RFS

Your reference: SSD-54836993
Our reference: DA20230220000698-Response to
Submissions-2

State Significant Development - Response to Submissions - Residential Subdivision/Masterplan

Stage 2 Huntlee NSW 2335, 12//DP1137569, 11//DP1137569, 3//DP813163, 4//DP813163, 13//DP1137569, 146//DP1233016

HUNTLEE STAGE 2 DA VILLAGE 2
CENTRAL & SOUTH DETAILED
SUBDIVISION BAL PLAN (3)

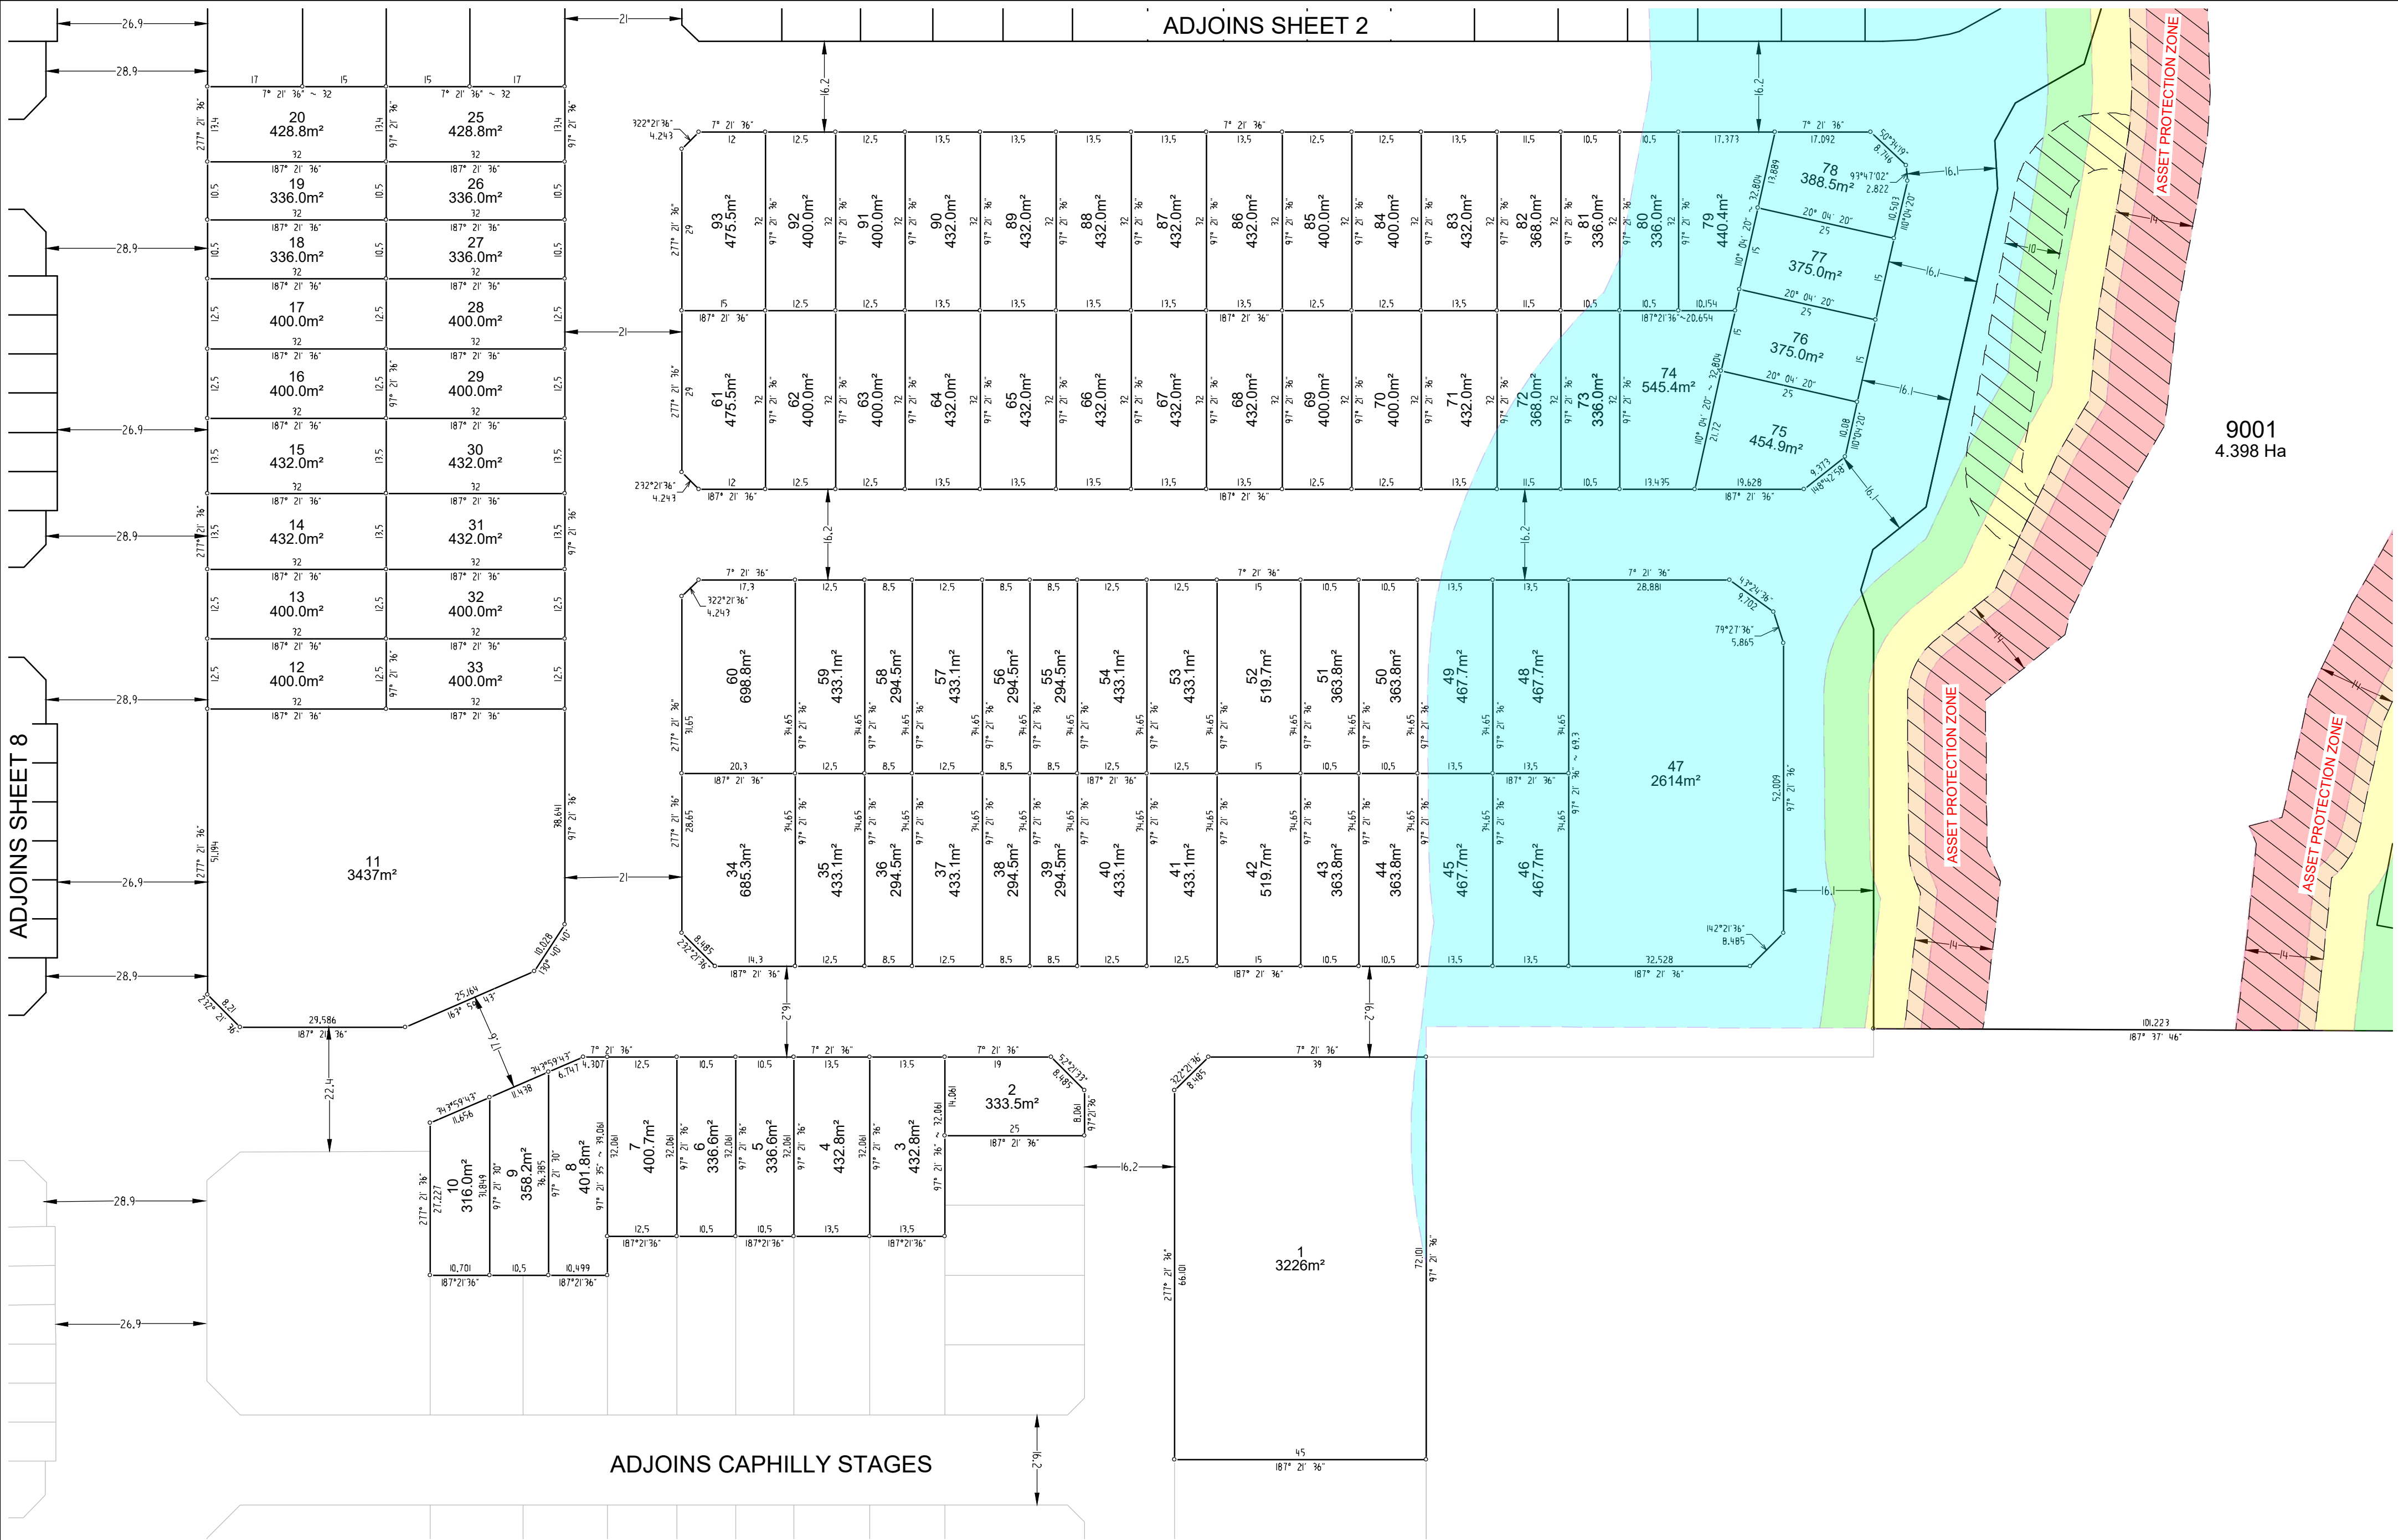
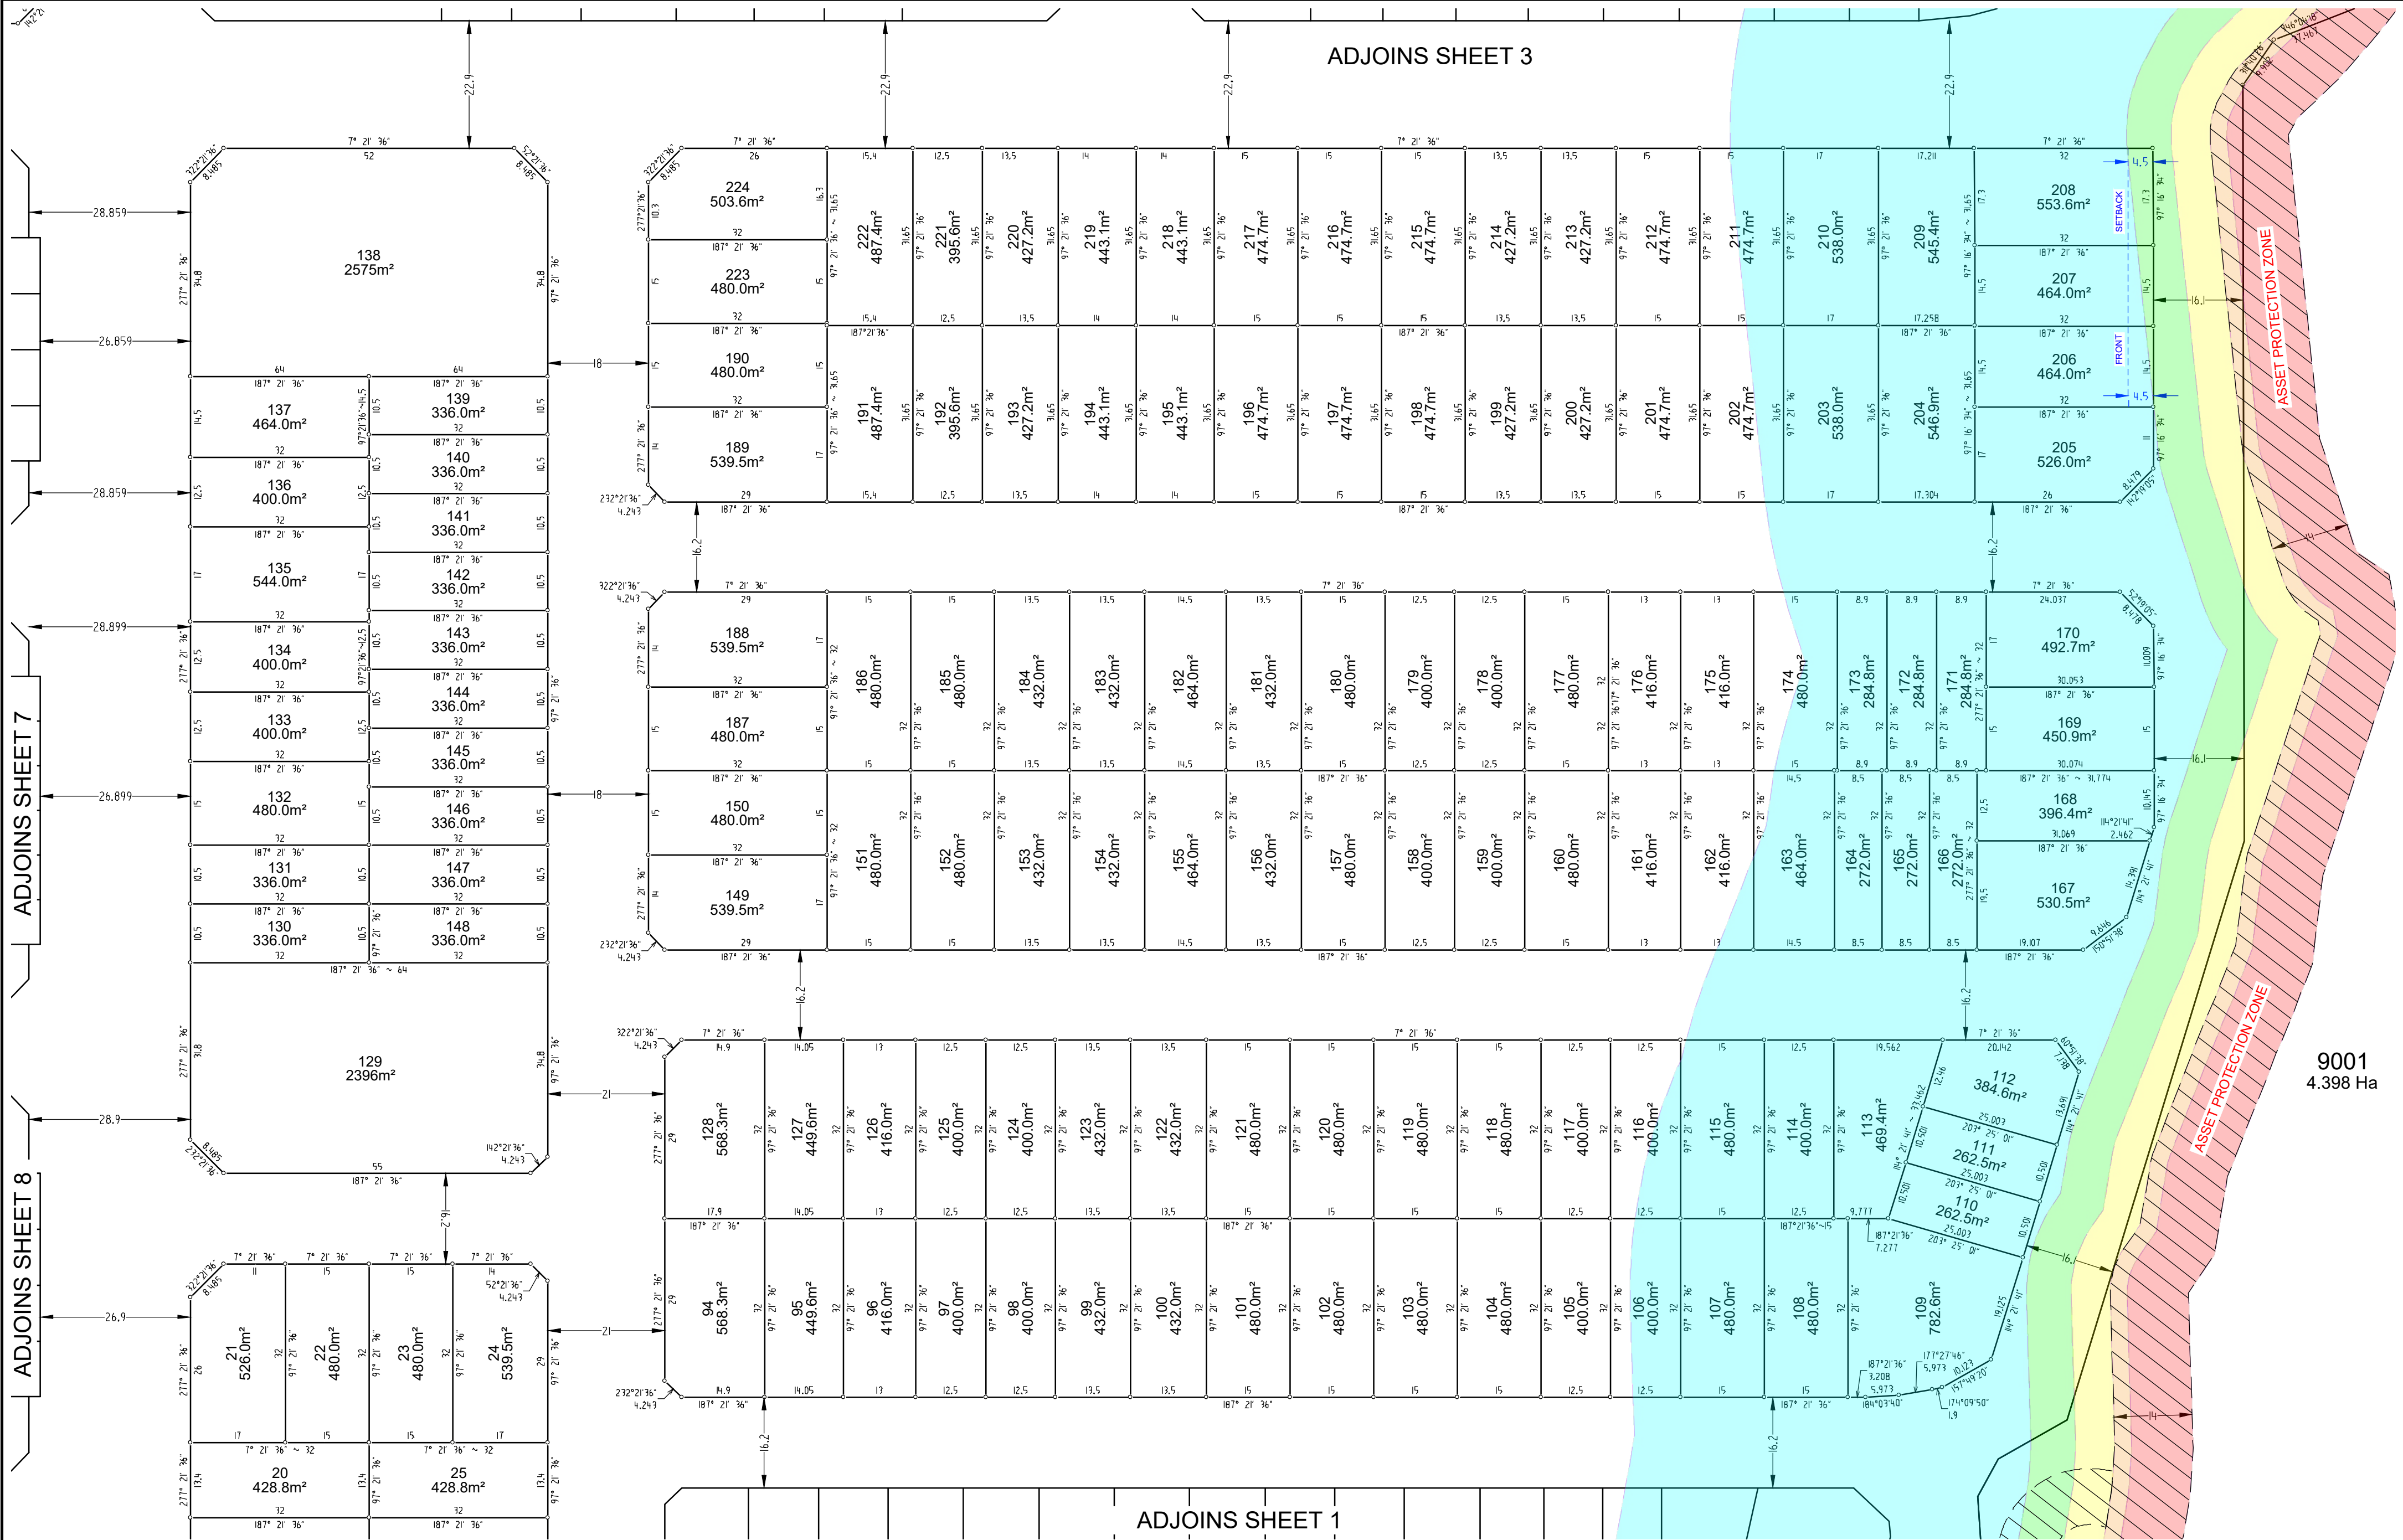
- With regard to Condition 3, the following matters need to be addressed for the bush fire attack level (BAL) Table and BAL-Plan provided in the bush fire report:

1. For clarity at the construction stage, the required setbacks are to be identified in metres on the BAL Plan as the distances for the BAL levels vary around the subdivision,

2. The BAL ratings applicable to each band of the BAL Plan are to be clearly identified on the plans,
 3. References to BAL-12 throughout the BAL Table must be amended to BAL-12.5,

- Review BAL Table for duplication of lot no. 799-806 (Sheets 6 & 7).
